# RICHMOND AMERICAN HOMES LOT 127 PLOT PLAN

*\* Remove + Replace Deck  
\* 4' High  
\* 230 square feet  
\* Uncovered*

ADDRESS: 330 AVOCET LOOP

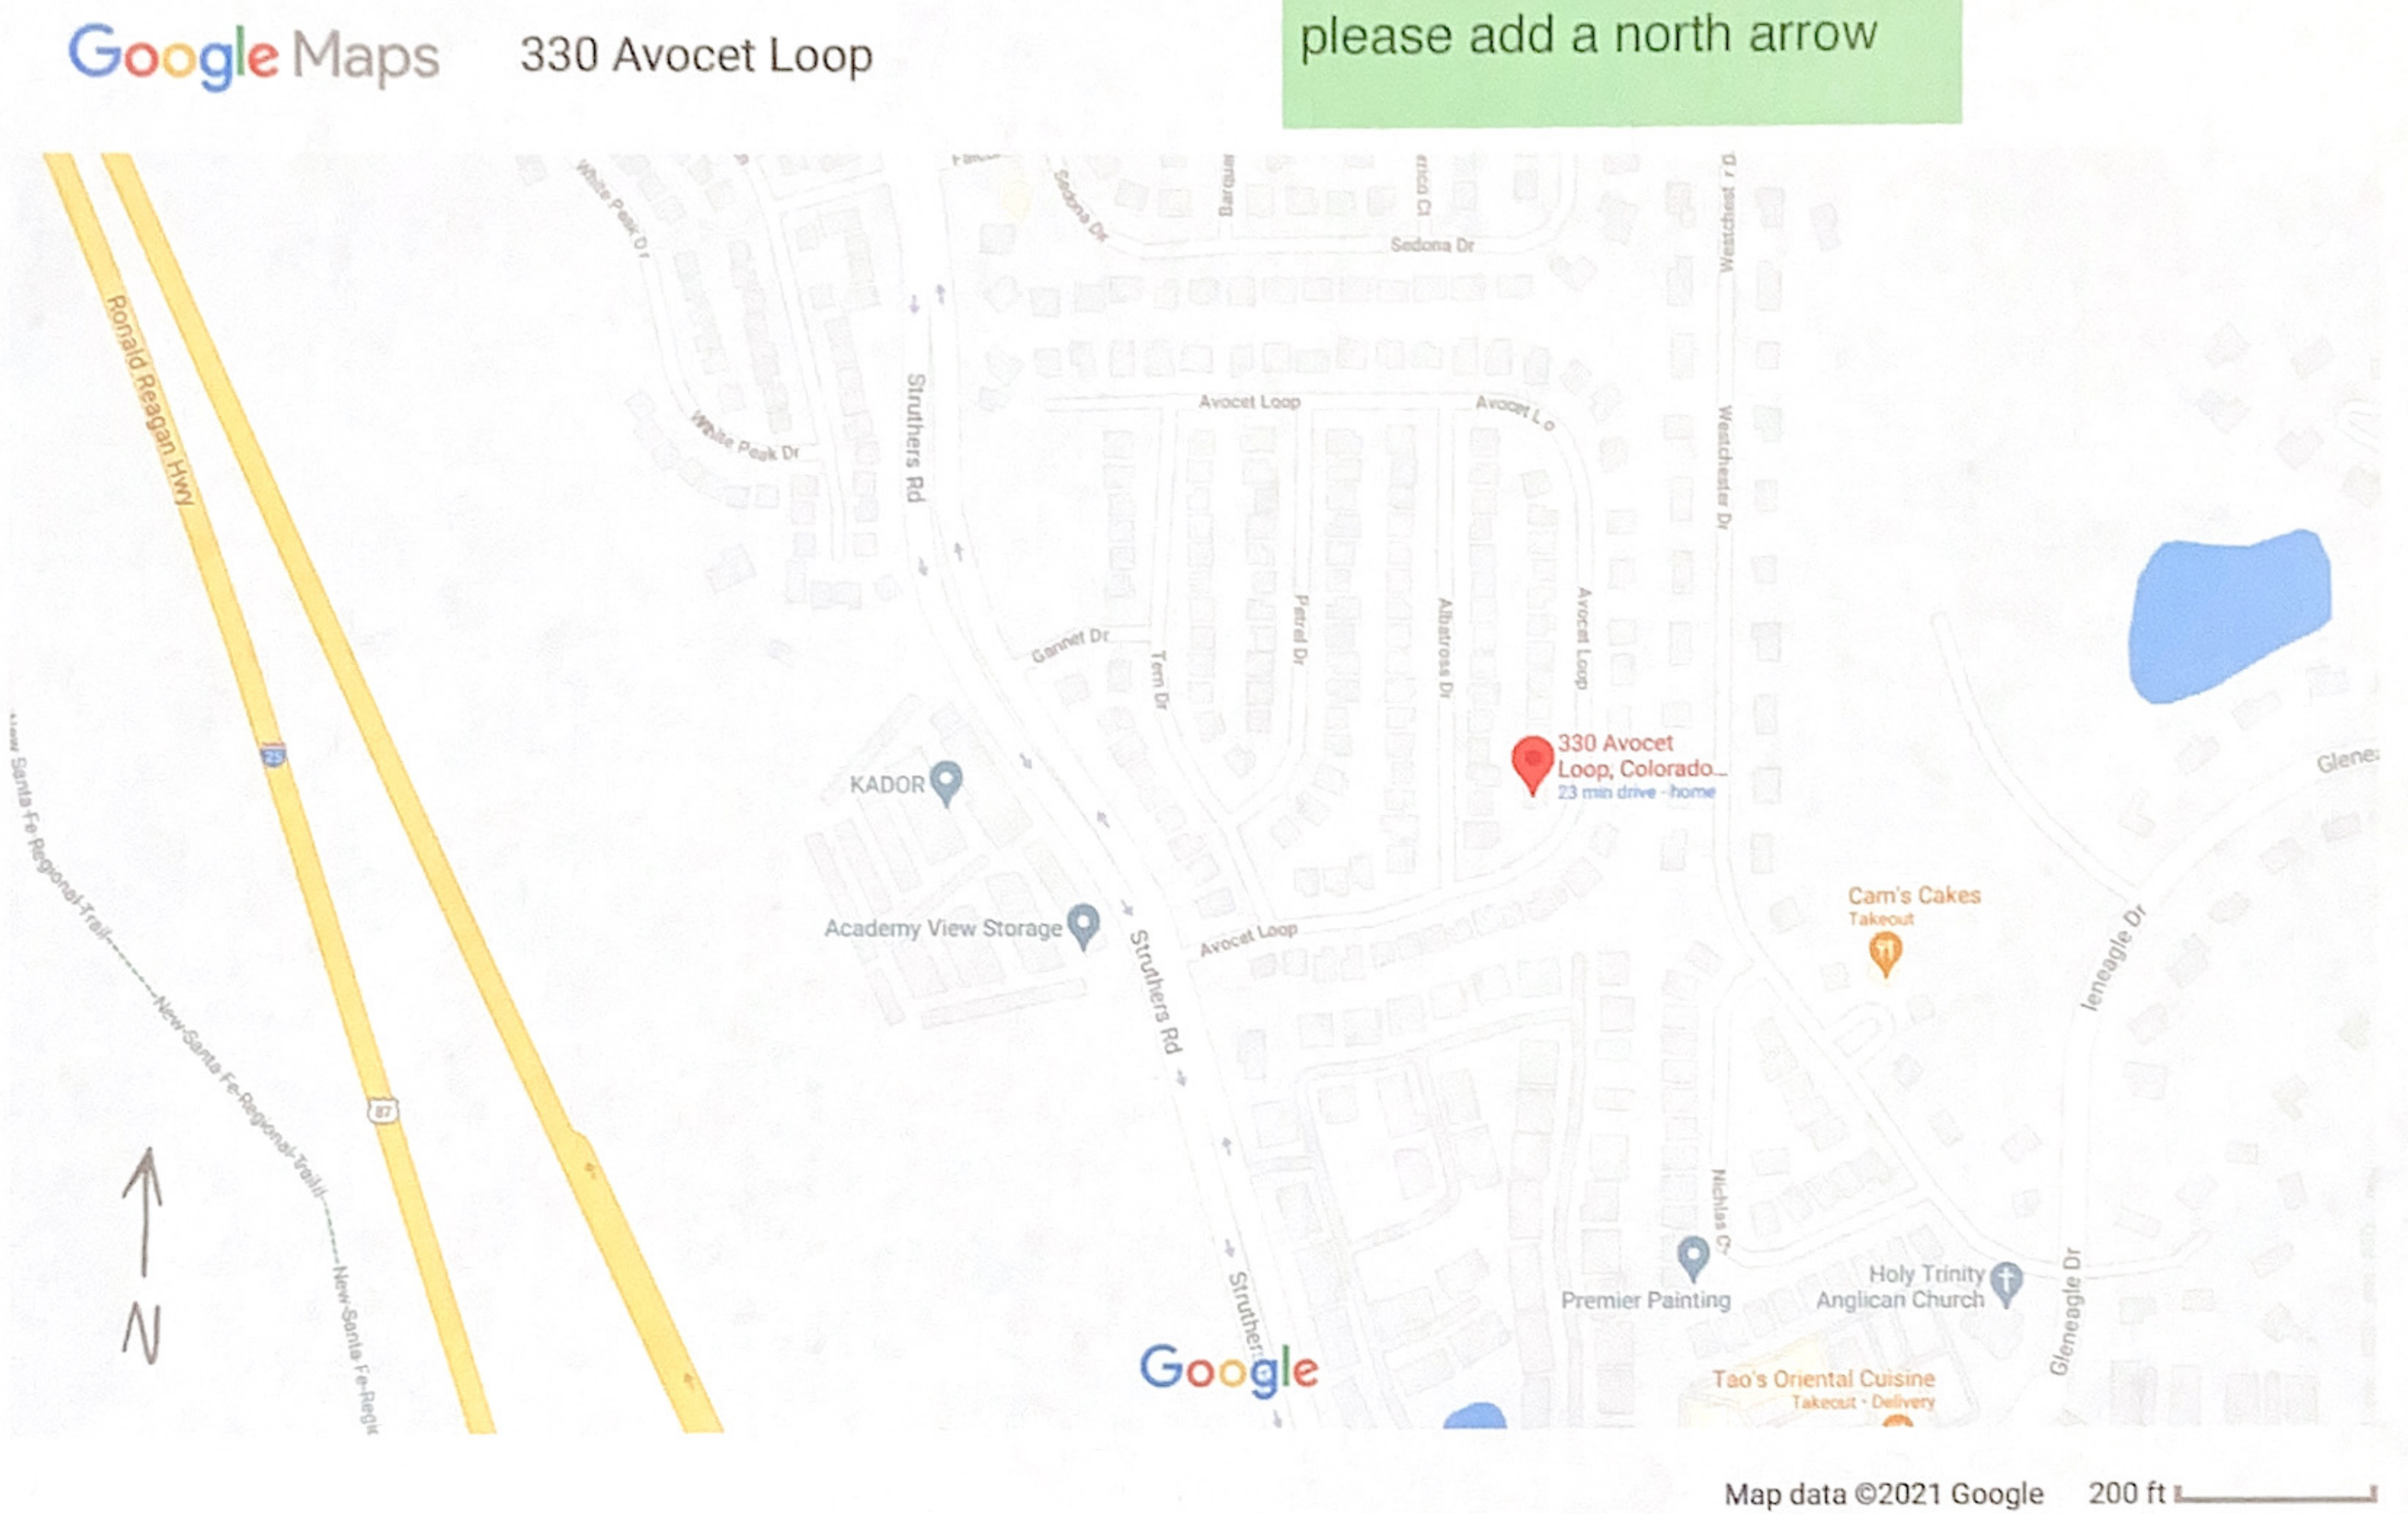
please add the following to the site plan:  
Existing/proposed land use and zoning

Please add "PCD  
File No. ADR218"
